Lane Cove Council

Redevelopment of Greenwich Hospital (Concept Proposal) at 97-115 River Road Greenwich (SSD8699) Amended proposal.

Ordinary Council Meeting 18 November 2019
COUNCIL SUBMISSION TO DEPARTMENT OF PLANNING ON GREENWICH HOSPITAL
REDEVELOPMENT

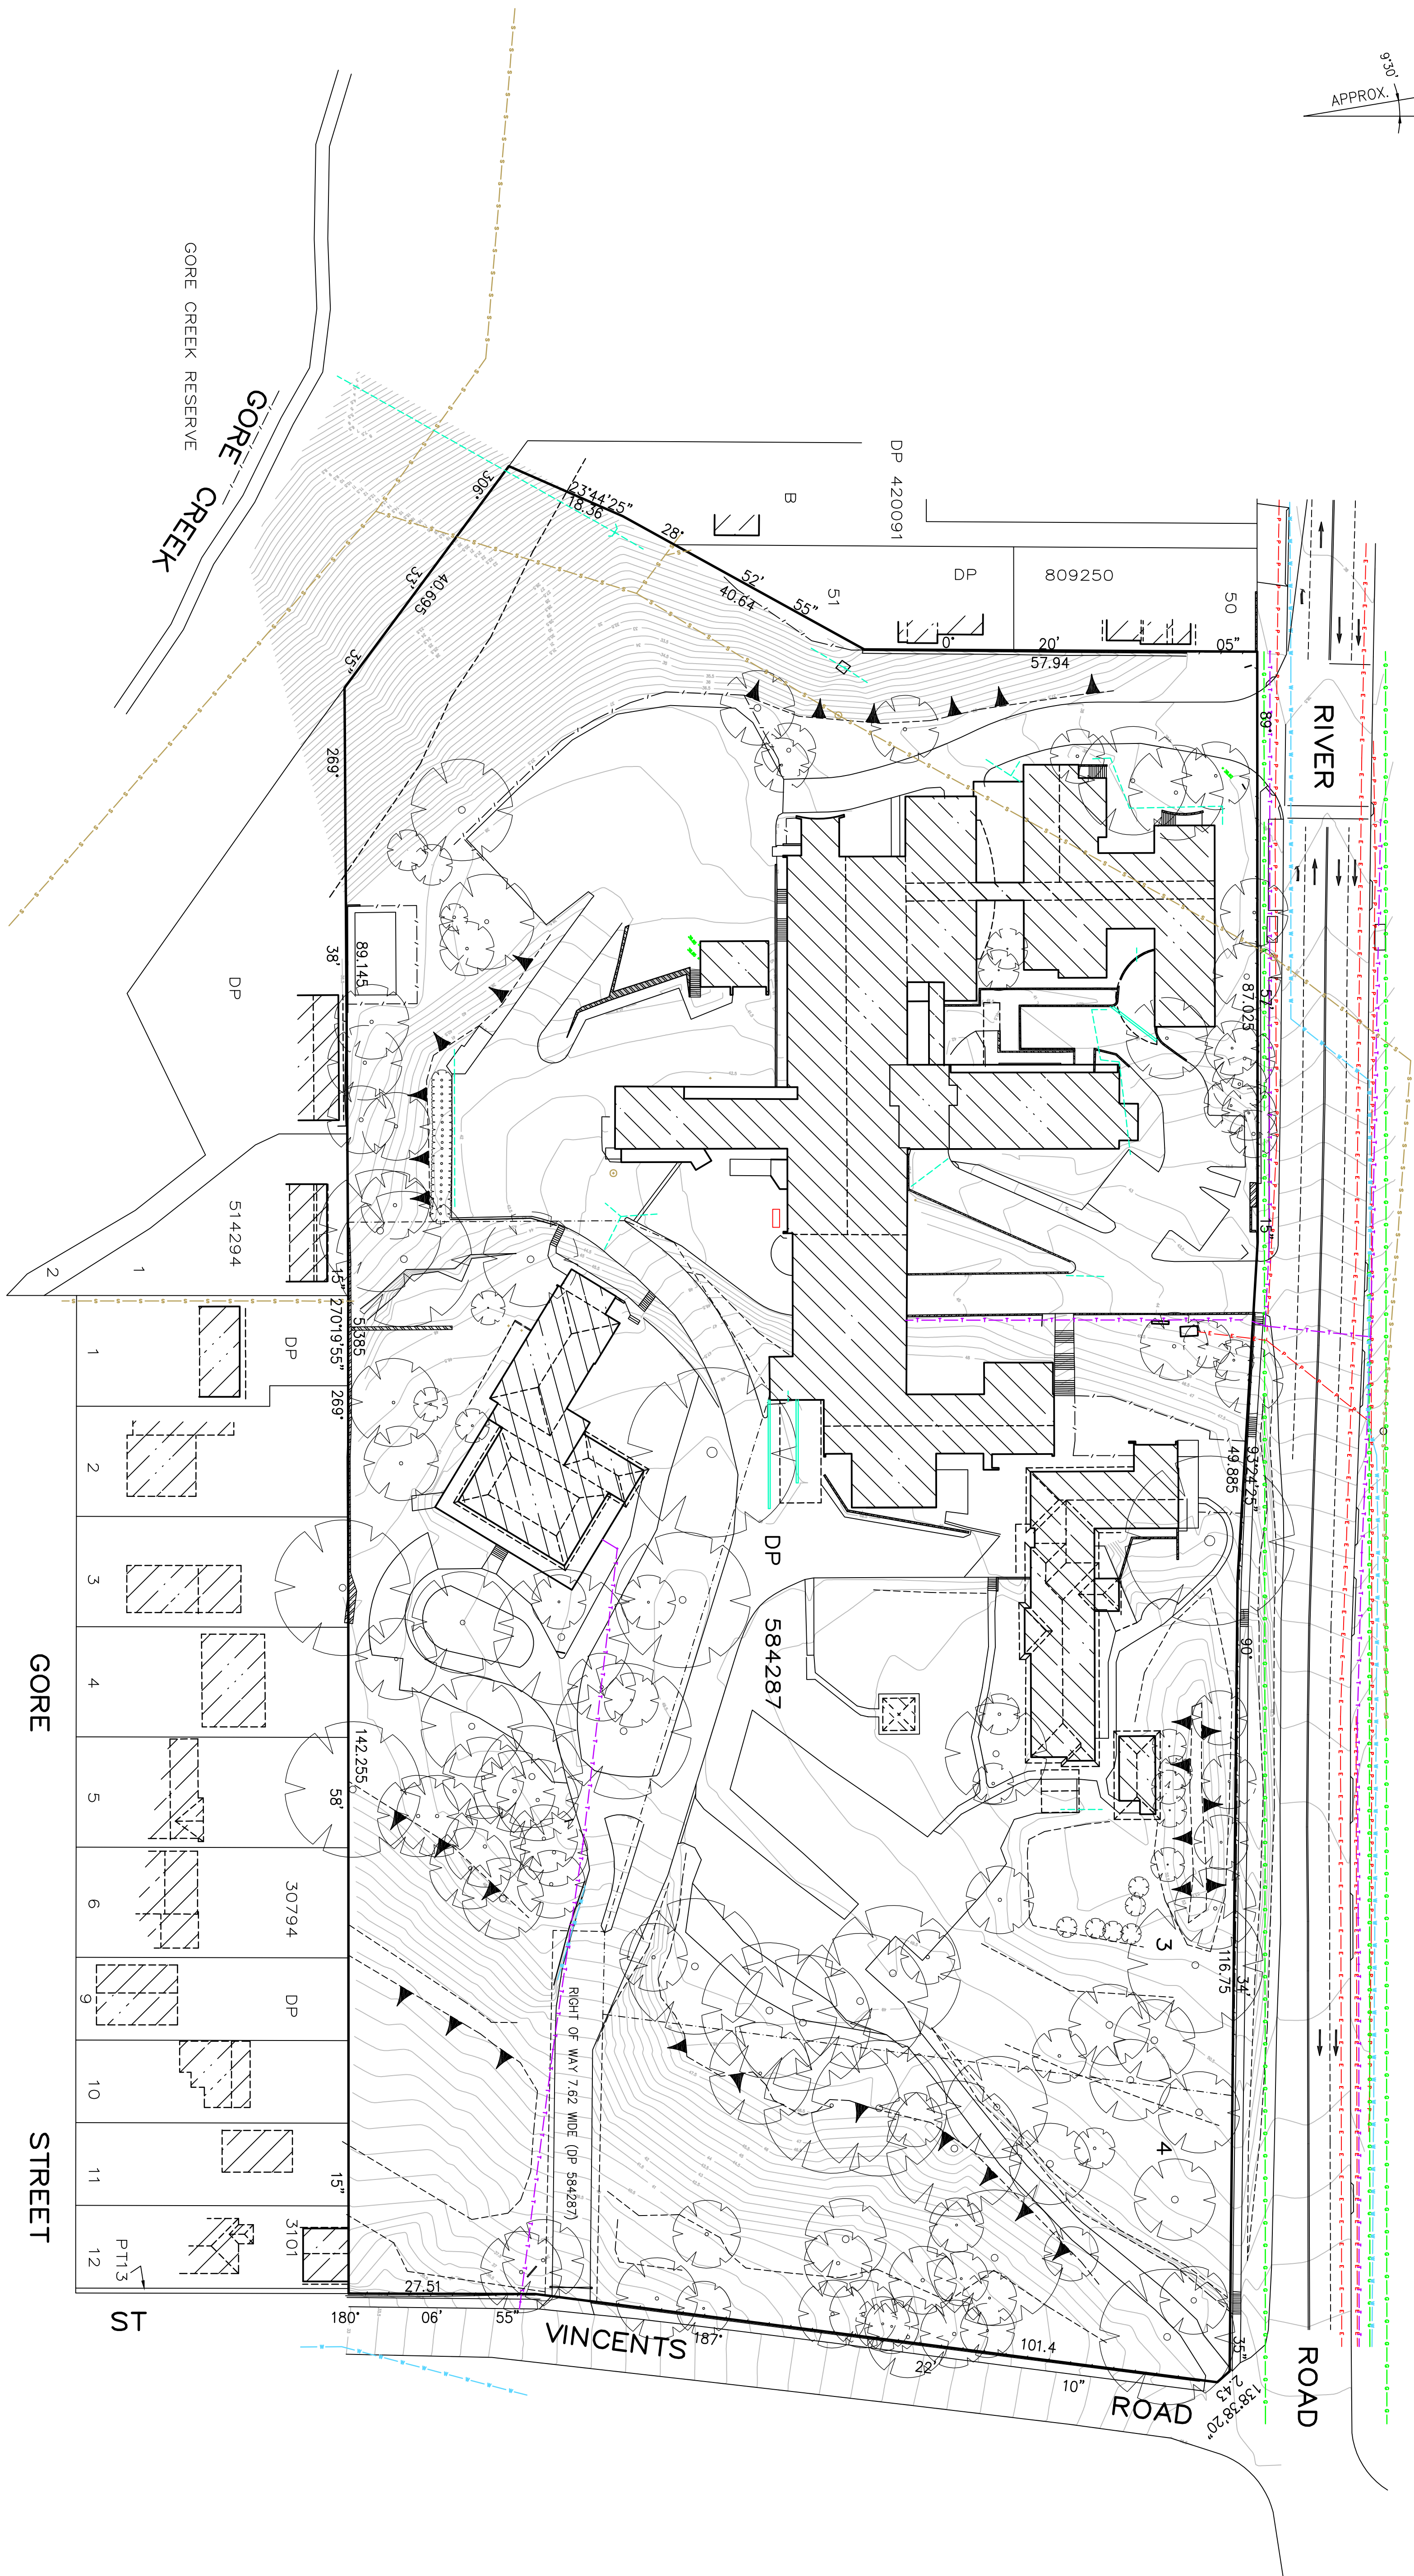
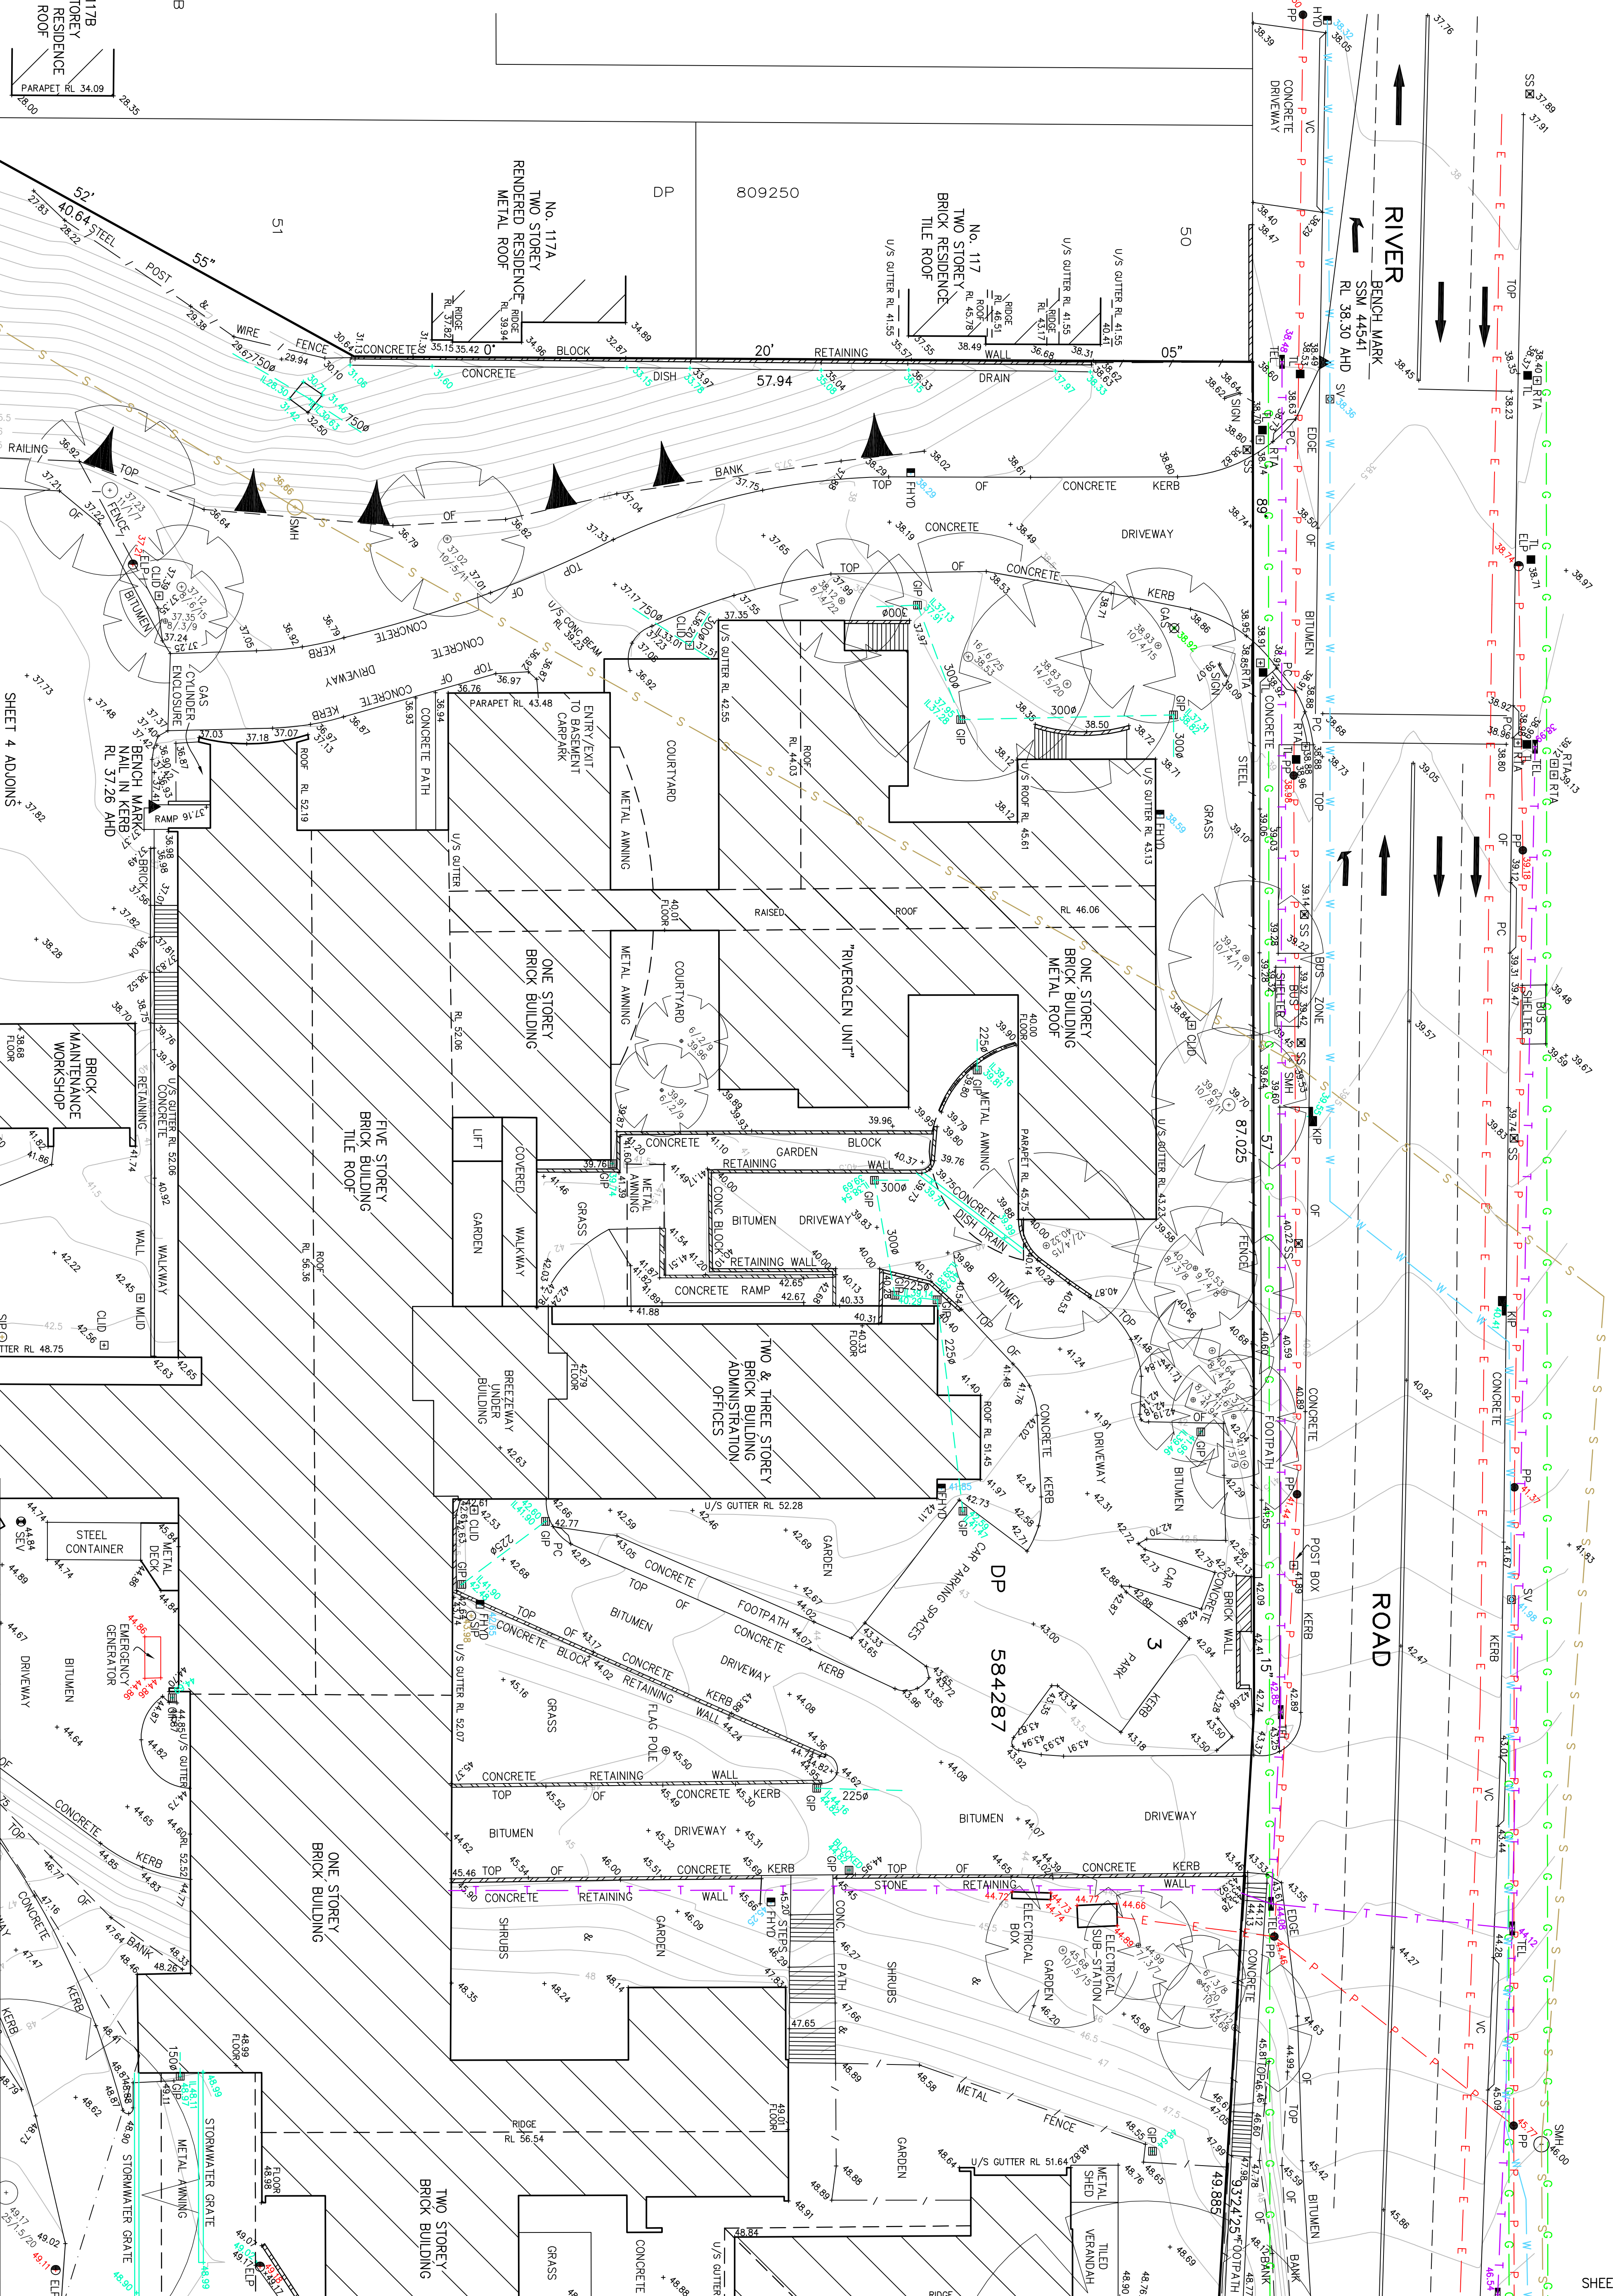
- The contours are incorrect on the south west corner resulting in the shadow analysis being incorrect. The contours are steeper than the survey conducted, which is reflected in the Civil Engineering documentation.
